**KIRKLEES METROPOLITAN COUNCIL
INVESTMENT & REGENERATION SERVICE**

**DELEGATED DECISION TO DETERMINE APPLICATIONS FOR
NON-MATERIAL AMENDMENTS**

Reference No: 2026/NM/91067/W

Site Address: Land off, Hermitage Park, Lepton, Huddersfield, HD8 0JU

CLIENT: MILLER HOMES
PROJECT: HERMITAGE PARK, LEPTON
DRAWING: SITE LAYOUT

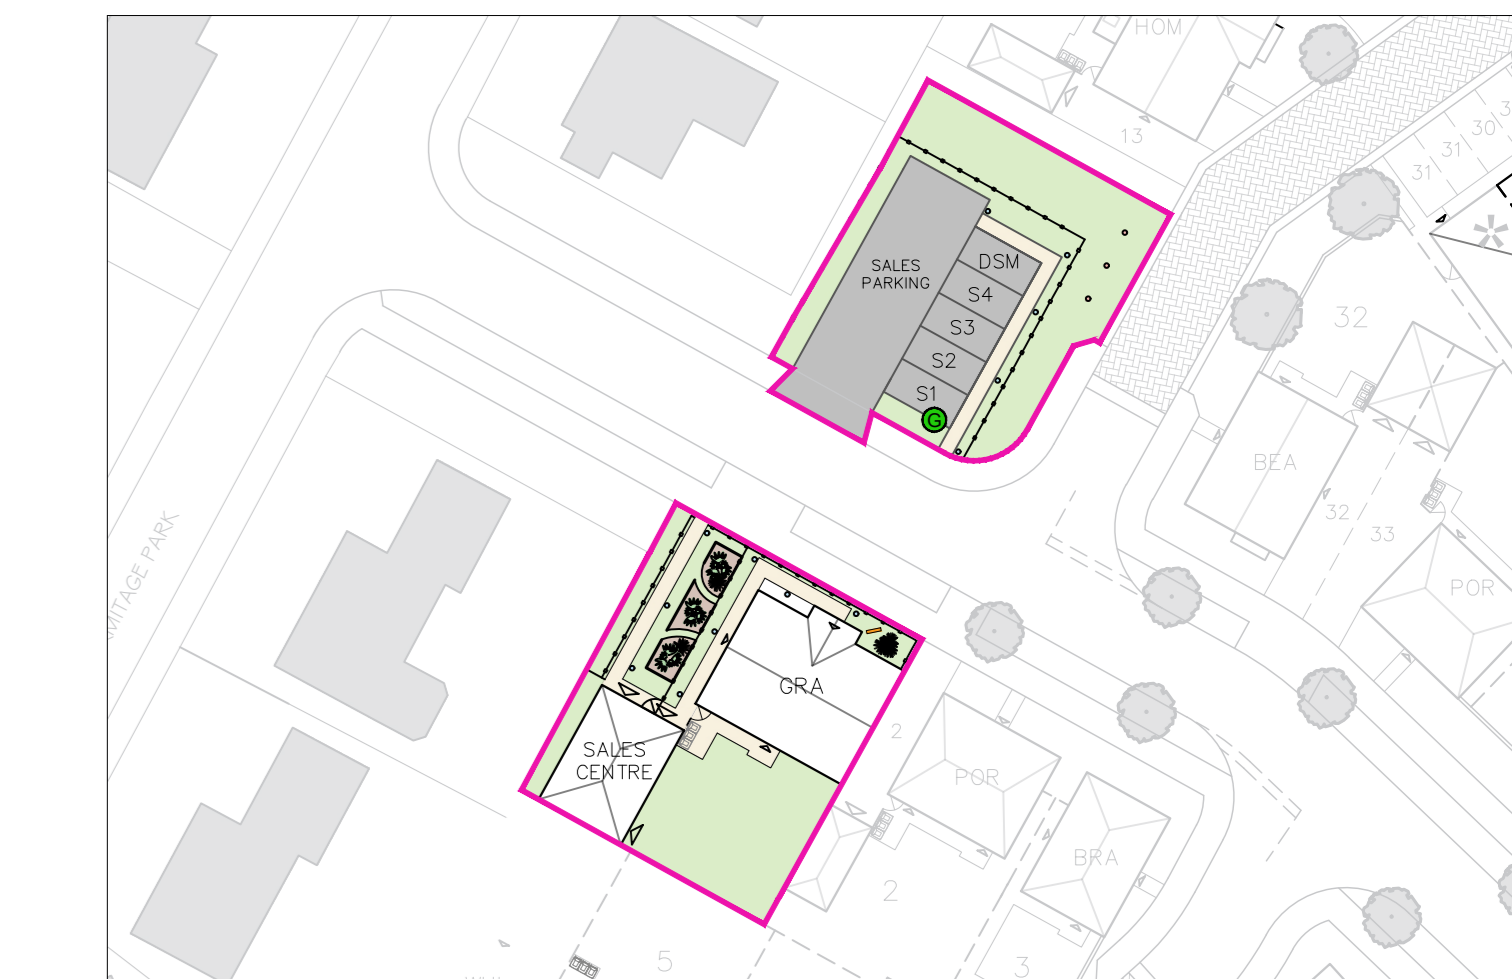
- Boundary between plots 9 and 10 amended, and boundary treatment set back from the road.
- Side door to house at plot 12 replaced with window.
- House at plot 15 handed, front parking spaces moved southeastwards.

- House at plot 16 moved southwards, garage moved northwards.
- Plot widths changed at plots 18 to 21.
- Houses at plots 19 and 20 (and detached garage at plot 20) moved eastwards.

- House at plot 21 changed from Greyford to Denford house type and moved northwards, garage (previously to be attached to garage of plot 22) and side driveway deleted, front hedge deleted.

- Garage at plot 22 now detached (no longer attached to garage at plot 21).
- Boundaries between plots 23, 24 and 33 to 36 amended.
- 1200mm vertical railings added to gardens of plots 6, 7, 8, 9 and 24 (and this newly-introduced railing added to drawing key).

- Houses at plots 23, 35 and 36 moved westwards.
- House at plot 33 moved northeastwards (away from the road).
- Garage at plot 34 moved northwards.
- Curtilage to plot 40 amended.

Of the proposed changes, the most significant are at plot 21, where the house type would be changed from a Greyford to a Denford, the house would be moved northwards, the garage (previously to be attached to garage of plot 22) and side driveway would be deleted, and the front hedge would be deleted to allow access to the repositioned driveway. During pre-application discussions, the case officer queried whether the move northwards was necessary, however the applicant advised that the front driveway length is proposed at

6m, and it is accepted that, in order to accommodate the Denford house type, this driveway length cannot be reduced without rendering the parking space deficient in terms of its size. It is also noted that the deletion of the garage from plot 21, and the proposed change of roof shape from pitched to hipped, would help reduce the massing seen from the north. While the proposed 1.15m northwards move is over (but close to) the limit of what would normally be accepted under an NMA application, given all the relevant considerations, it is considered that the impacts on 34 Rowley Lane (in terms of sense of enclosure and outlook) are, on balance, acceptable. Regarding privacy and overlooking, the house at plot 21 would be nearer to 34 Rowley Lane and would have three rear bedroom windows (looking north) at first floor level (instead of the two rear bedroom windows of the Greyford unit previously approved here), however – taking into account the locations of the windows of other plots along this northern boundary – it is considered that the proposed changes at plot 21 would not materially affect the degree of overlooking that would be experienced by existing neighbouring residents to the north. It is further noted that – according to the applicant, as stated in an email dated 25/02/2026 – a distance of 26m would be maintained from the rear windows of the house at plot 21 to the habitable windows of the neighbouring dwelling to the north, exceeding the 21m normally required.

In aesthetic terms, there is no concern regarding the introduction of a Denford unit at plot 21. That house type has already been previously approved elsewhere within the site and its siting here would not detract from the visual amenity of the Streetscene or wider development.

The loss of the front boundary hedge from plot 21 (a hedge that would have been approximately 6m long) is unfortunate given the importance of boundary hedges to the development (and their role in addressing the development's shortfall in street trees), however the proposed extent of loss is not considered material in the context of what would be provided elsewhere within the site.

The other changes proposed along the northern boundary of the site (plots 15 to 22) are considered minor, and raise no concerns in relation to design or amenity.

Three off-street parking spaces would be provided within plot 21, which is considered acceptable. Other changes would not reduce the level of off-street parking previously approved. The minor amendments to two private drives (and the driveways and parking spaces accessed off them) raise no concerns in relation to highway safety.

It is considered that the proposed amendments would not have a detrimental impact on visual amenity or living conditions, nor would they be detrimental to a third party. The amendments are considered to be in accordance with protocol, and it is therefore recommended that the Non-Material Amendments be approved.

# 405 / DENFORD (PLOTS 11, 19, 21, 41 & 54) PLANS & ELEVATIONS

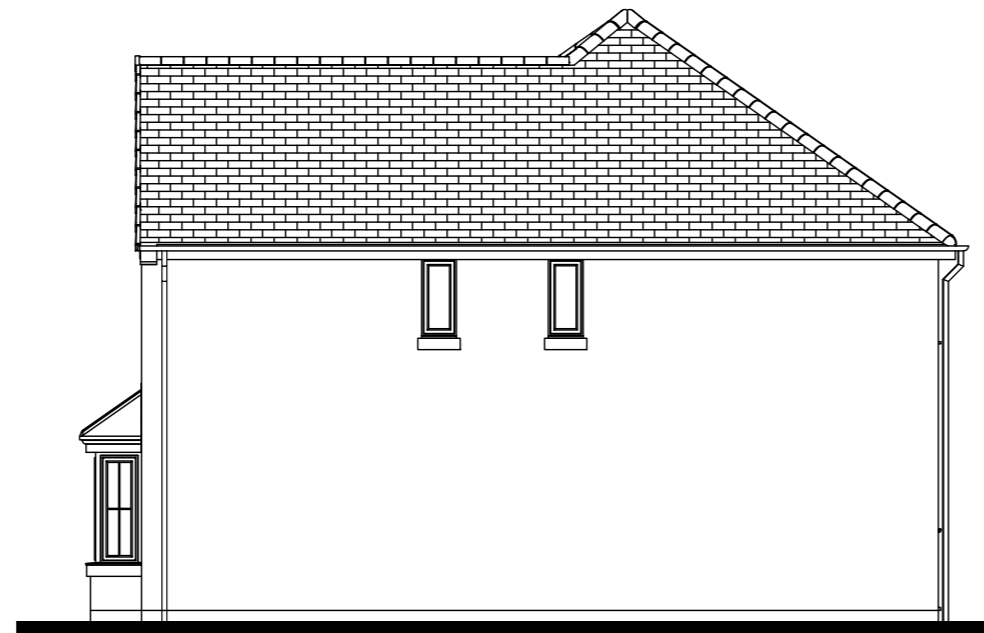
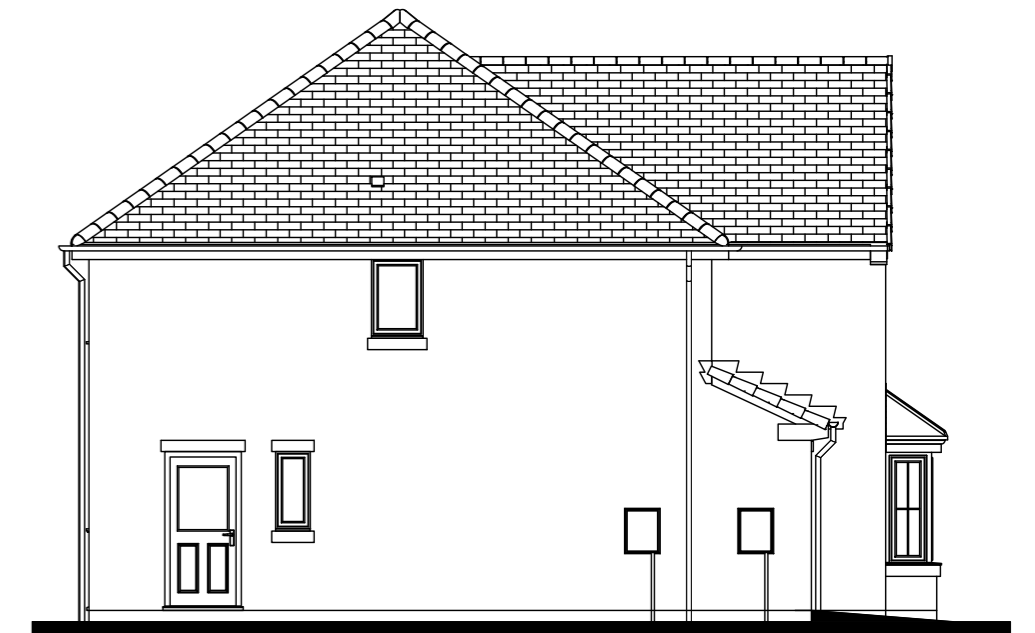
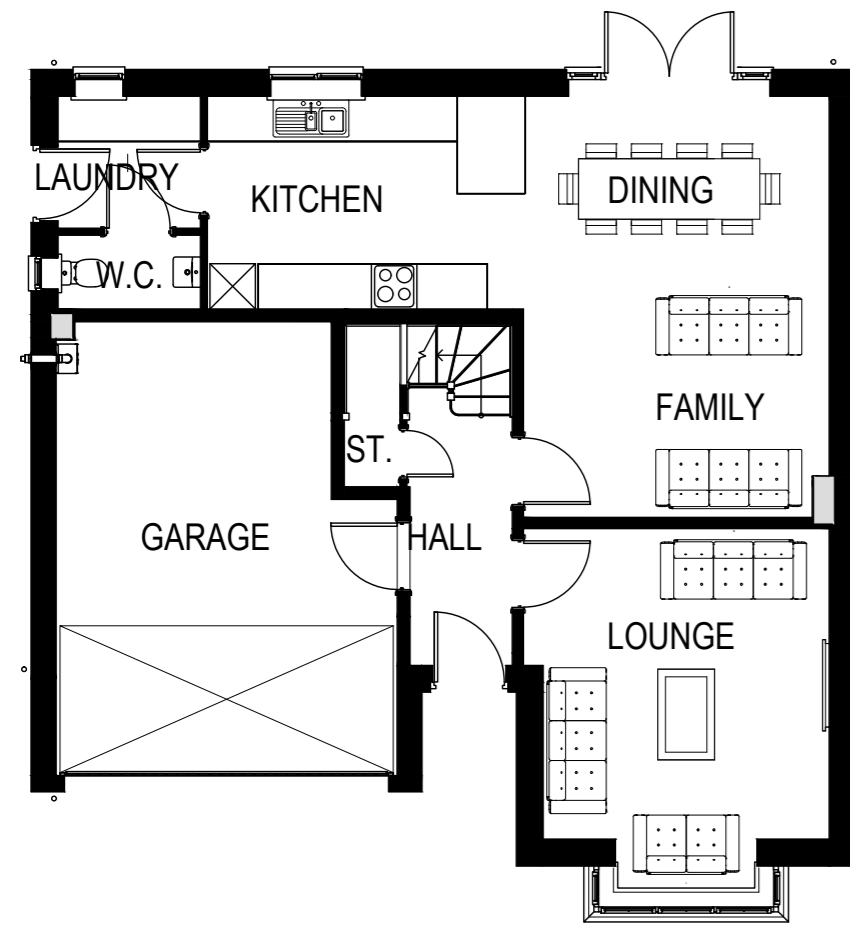
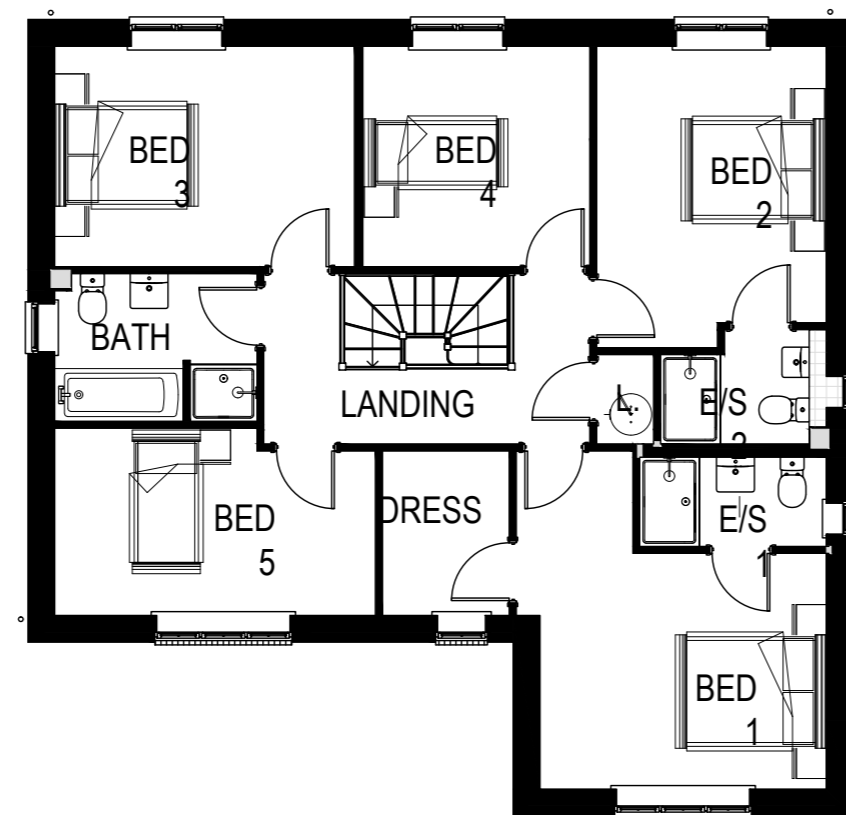
The proposed changes would not affect the development's unit size mix. The 5-bedroom Denford unit proposed at plot 21 would replace a 5-bedroom Greyford unit previously approved at that plot.

400 / GREYFORD (PLOT 12) PLANS & ELEVATIONS

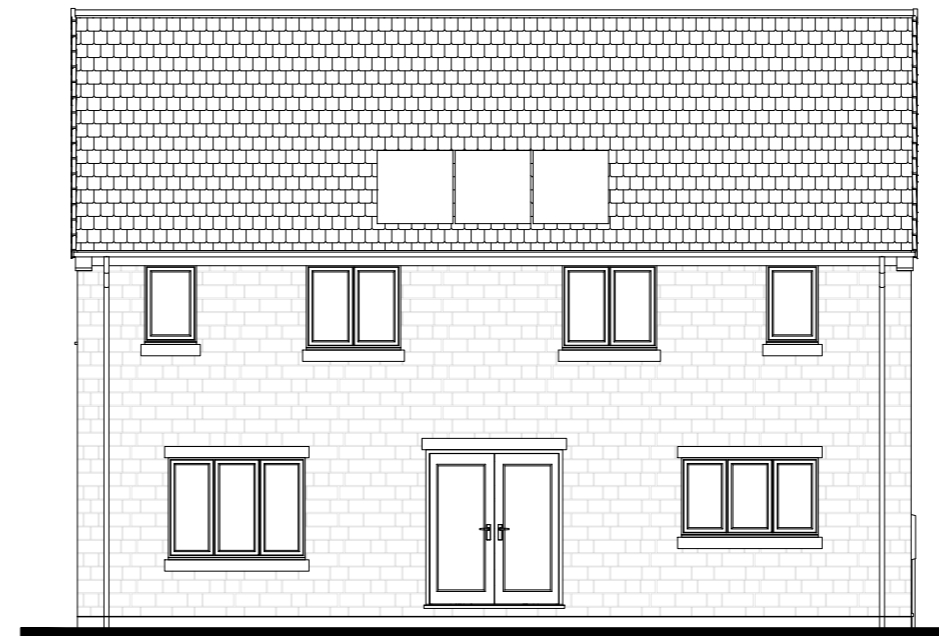
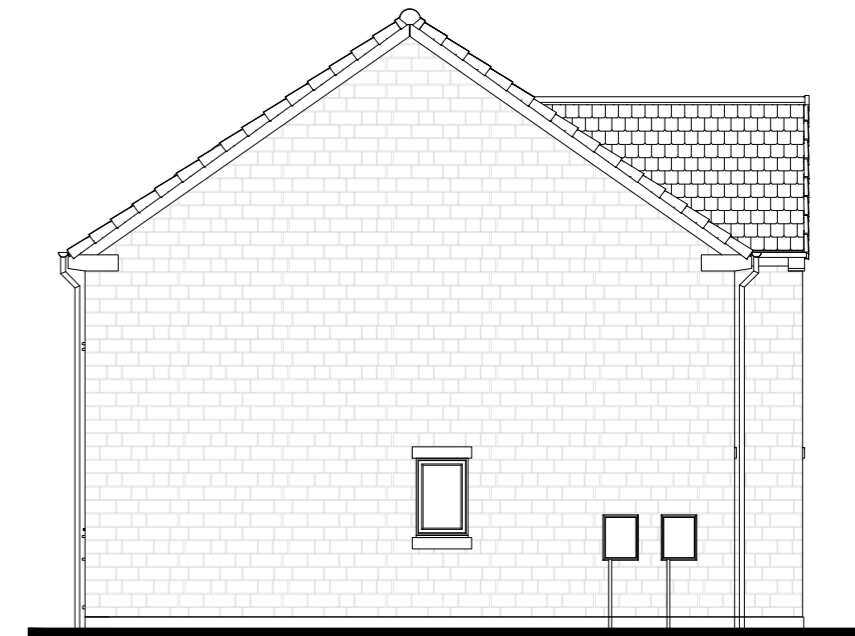
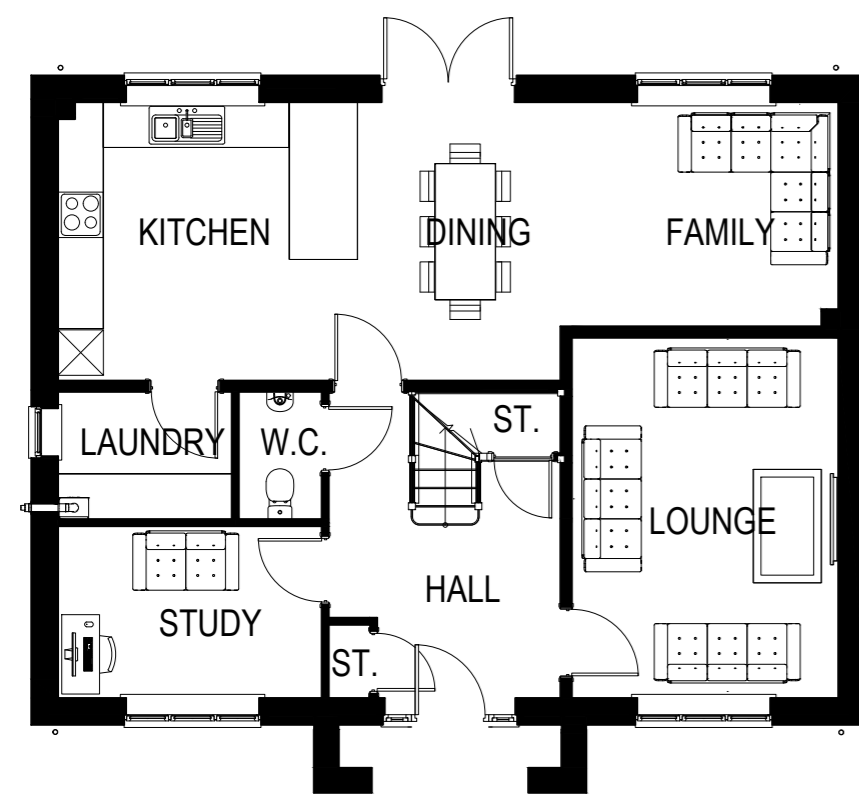
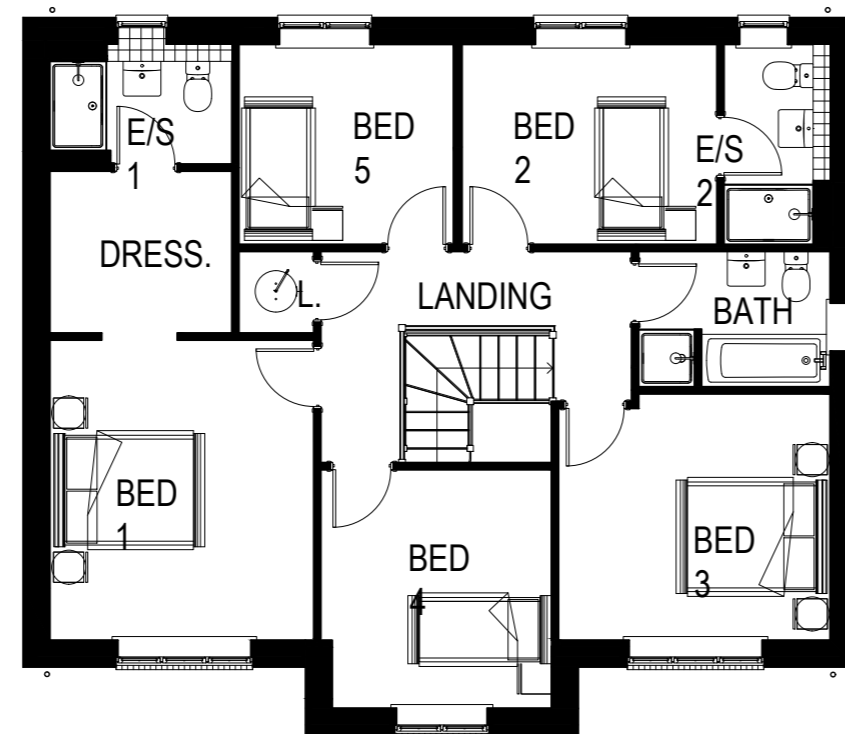
Away from the northern part of the site, the changes proposed at plots 6 to 10, 12, 23, 24, 33 to 36 and 40 raise no significant concerns. The proposed change of a door to a window in the side elevation of the house at plot 12 (facing the rear boundary of 16 Hermitage Park) raises no amenity or aesthetic concerns. The additional boundary treatment (a 1200mm vertical railing) would not adversely affect neighbouring amenity where it is proposed at plots 6, 7 and 8, given its limited height, its design, its proposed location, and the intervening vegetation. Other changes to plots involve adjustments to plot curtilages and minor changes to the locations of houses within plots, none of which would result in any dwelling being deficient in amenity, garden space or parking spaces.
